Rezoning Transportation Analysis

Petition Number: 2020-138

General Location Identifier: Tax ID (08705510)

SITE PLAN

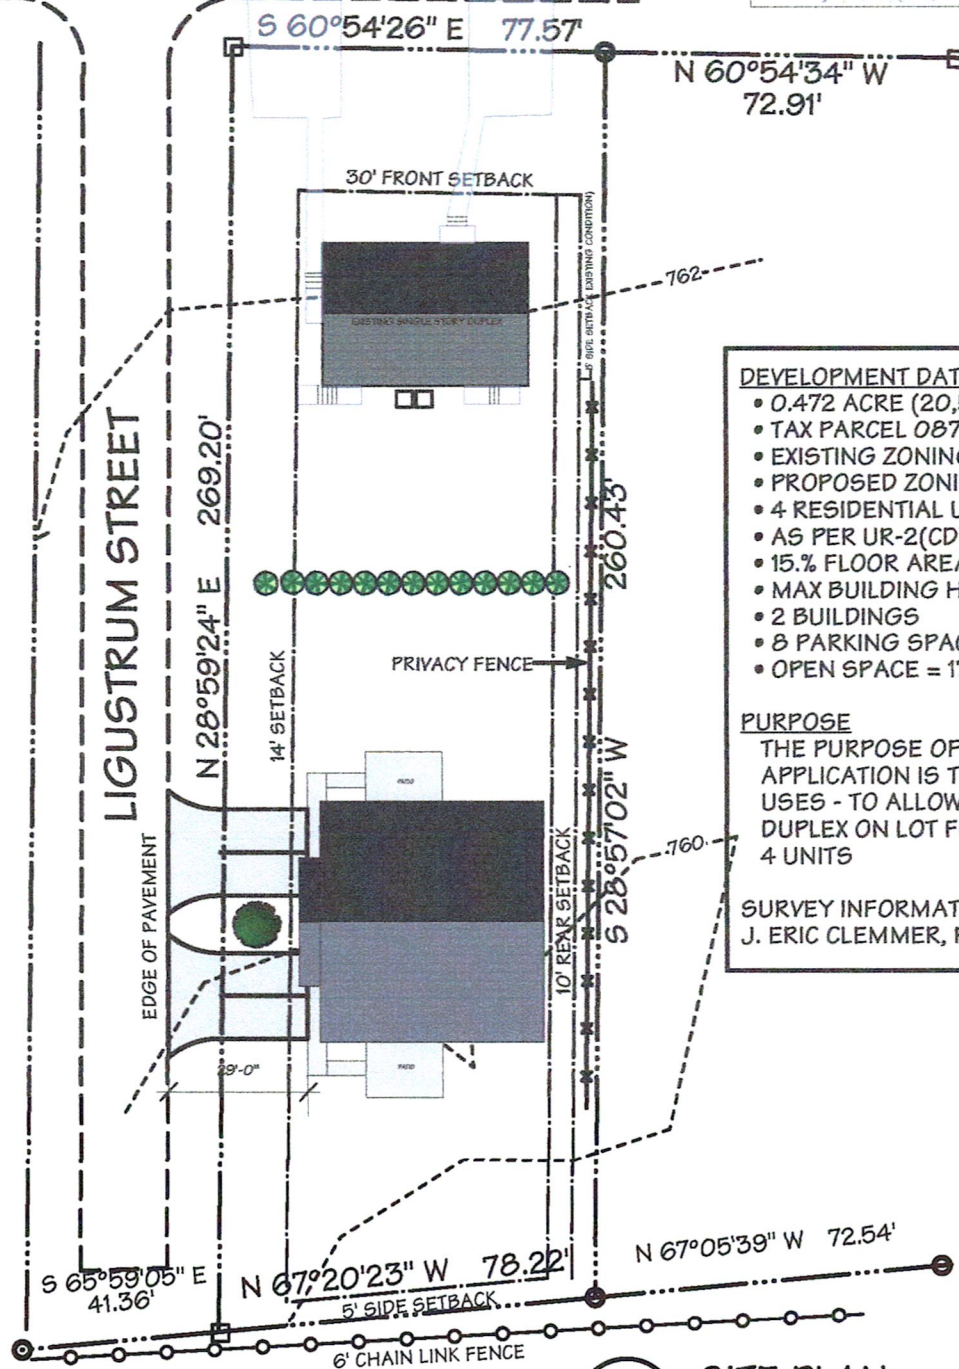
1. **Curbline:** The proposed zoning district has a setback measured from back of the existing or proposed future curbline.
 - a. **Rutgers Avenue:** Location of curb and gutter should be installed at the existing edge of pavement.
 - b. **Ligustrum Street:** Location of curb and gutter should be installed at the existing edge of pavement.

Label and dimension curb and gutter from the centerline for each road on the site plan.

3. Revise site plan and conditional note(s) to commit to construct an 8-foot planting strip, and 6-foot sidewalk on Rutgers Avenue and Ligustrum Street, per Chapter 19 of the City Code and required within Chapter 9 of the Zoning Ordinance. Label and dimension both items from the back of curb and gutter and road centerline on the site plan.
4. Add site plan note(s) specifying dedication and fee simple conveyance of all rights-of-way to the City before the site's first building certificate of occupancy is issued. CDOT requests rights-of-way set at 2' behind back of sidewalk where feasible.
5. Add site plan note specifying that all transportation improvements will be approved and constructed before the site's first building certificate of occupancy is issued. The petitioner may phase transportation improvements if said improvements and phasing are explicitly described in site plan notes.
